**REQUEST**

Current Zoning: N1-A (neighborhood 1-A)  
Proposed Zoning: UR-2(CD) (urban residential, conditional)

Approximately 4.2 acres located on the north side of Galloway Road, east of Mallard Creek Road, and west of Garrison Road.

The petition proposes a residential community of up to 28 single-family attached dwelling units.

REZONING SITE PLAN

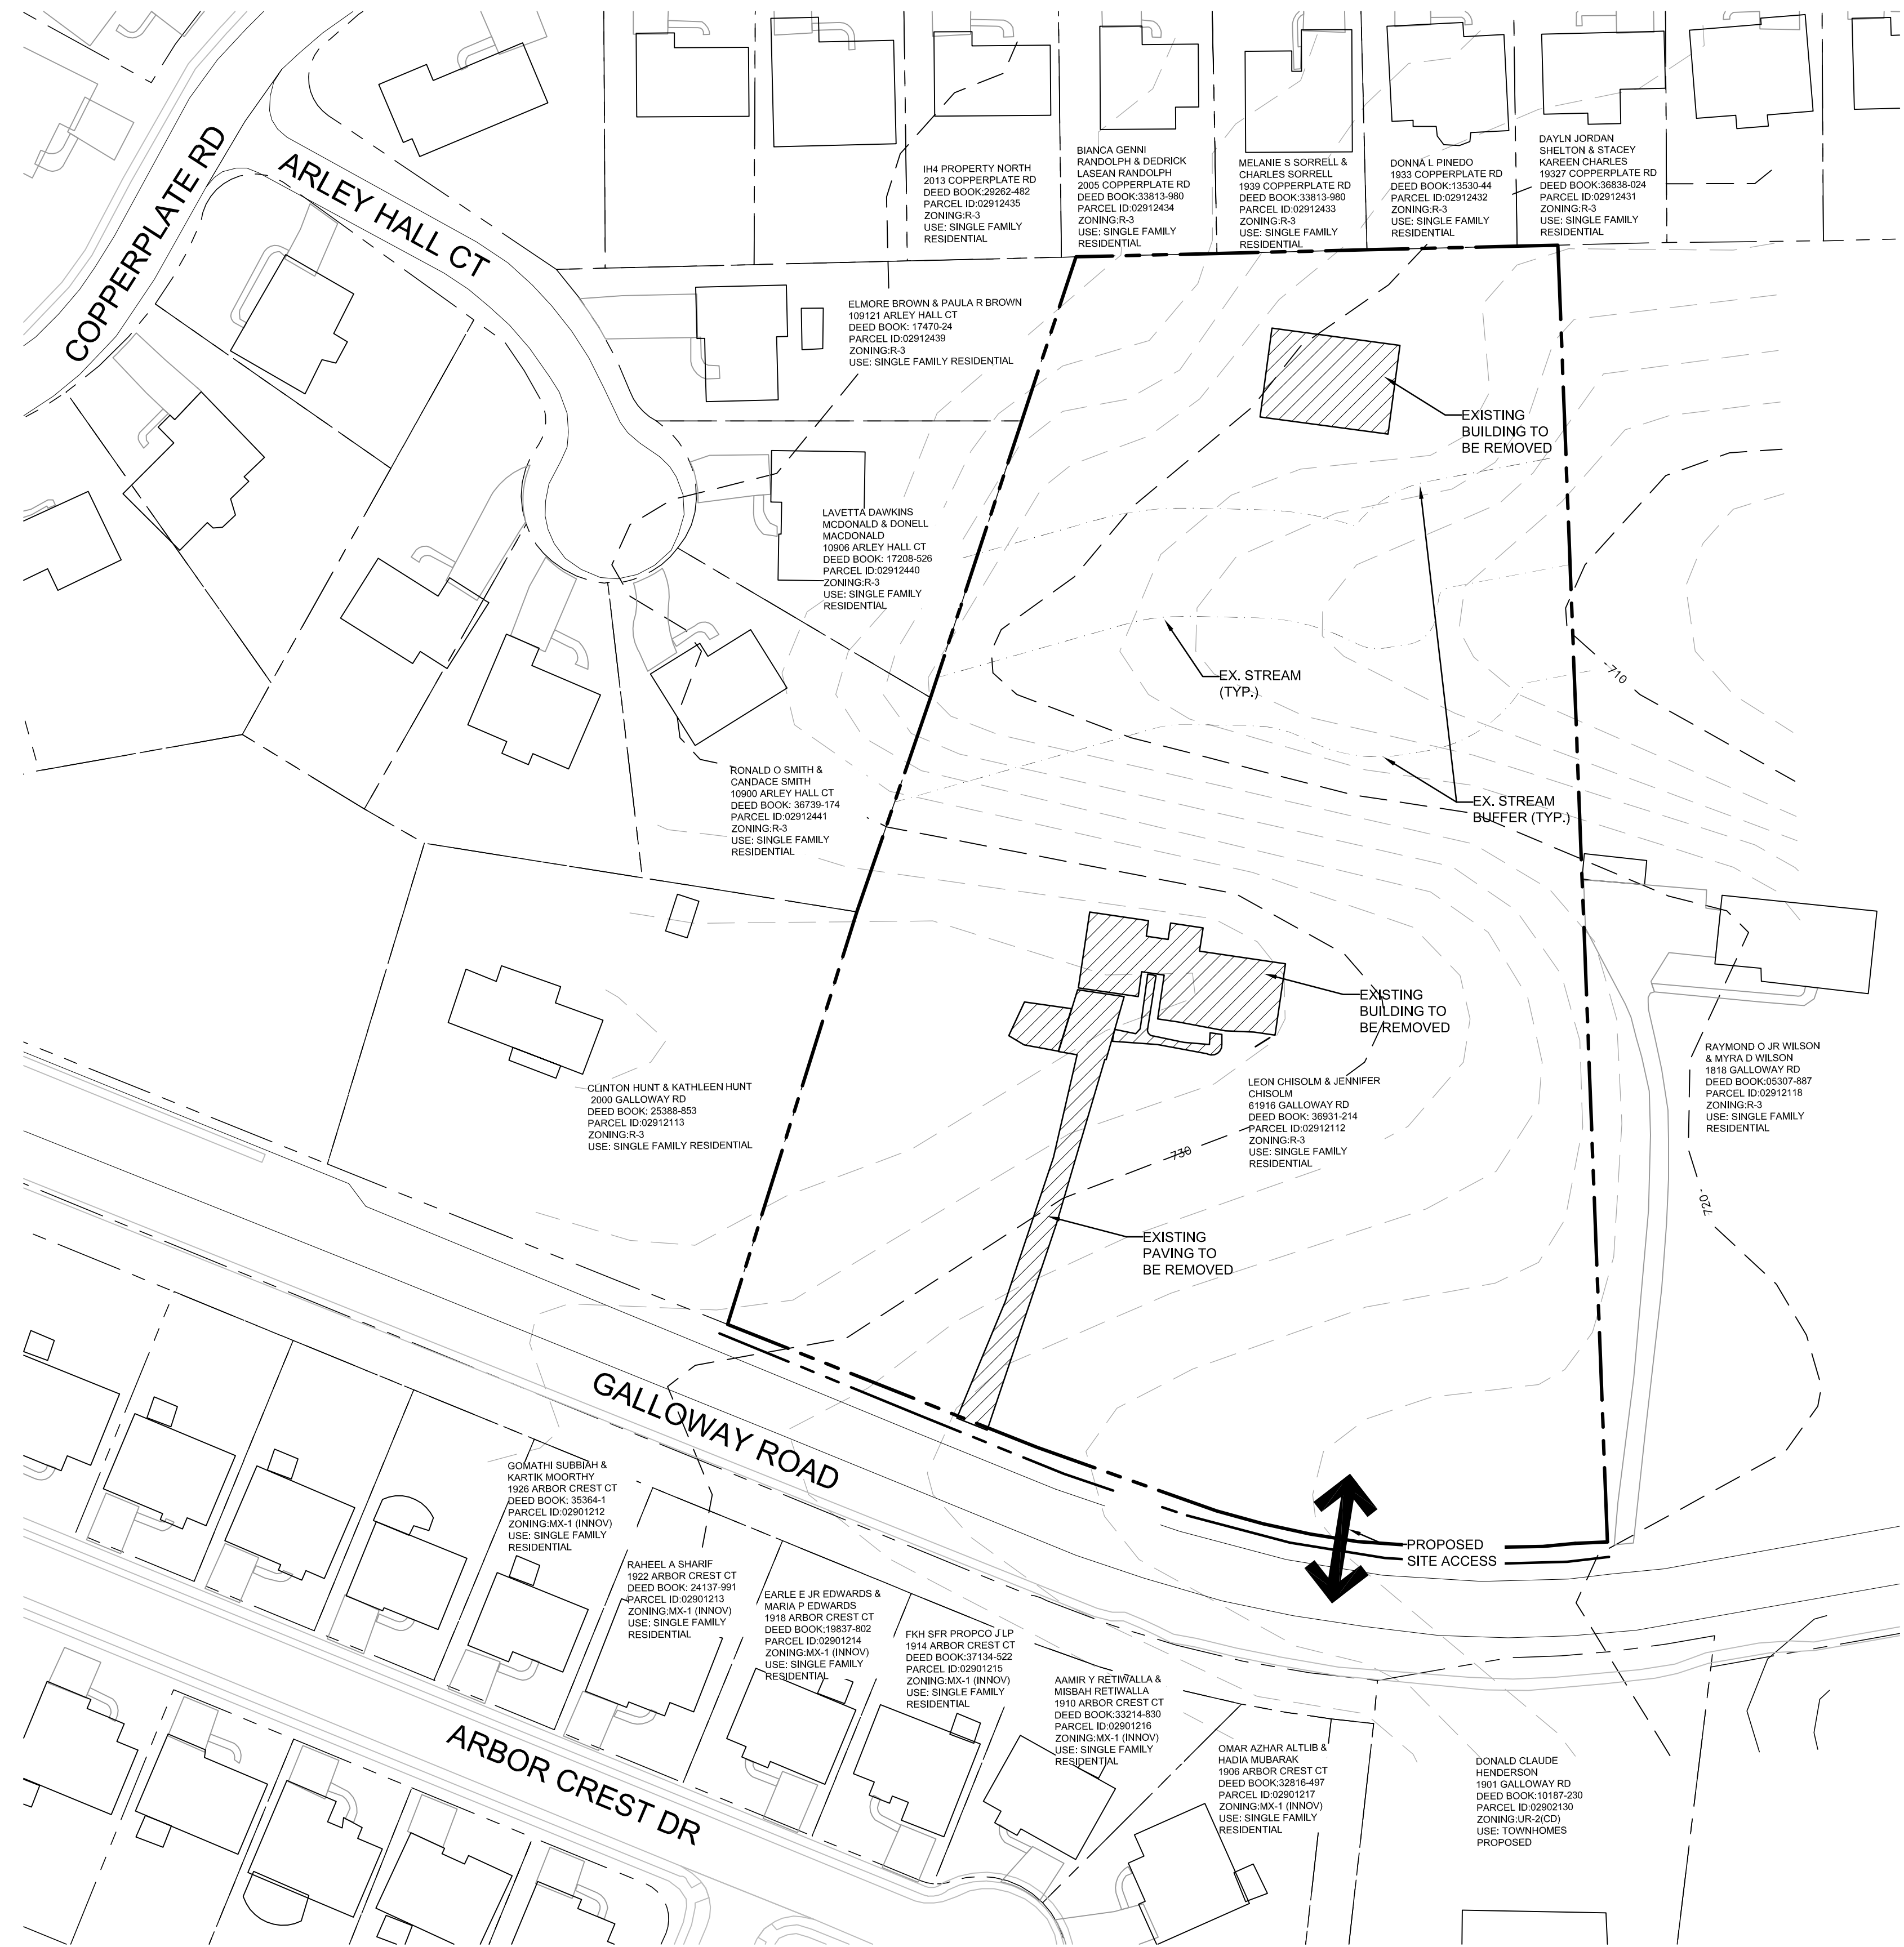
1. Remove "visible from", changing to "proposed along" to read: "Garage doors proposed along public..." for architectural note 8. **Addressed**
2. The setback in the site data table says 35' from BOC. please show correct setback. **Addressed**
3. The rear yard in site data table say 10'. Please add or 20' as shown. **Addressed**
4. Change the height in site data table to say 40', with allowance up to 48' per 9.406(2)(a) **Addressed**
5. Change architectural note 5 from 4 units to 3 units fronting Galloway Road. **Addressed**
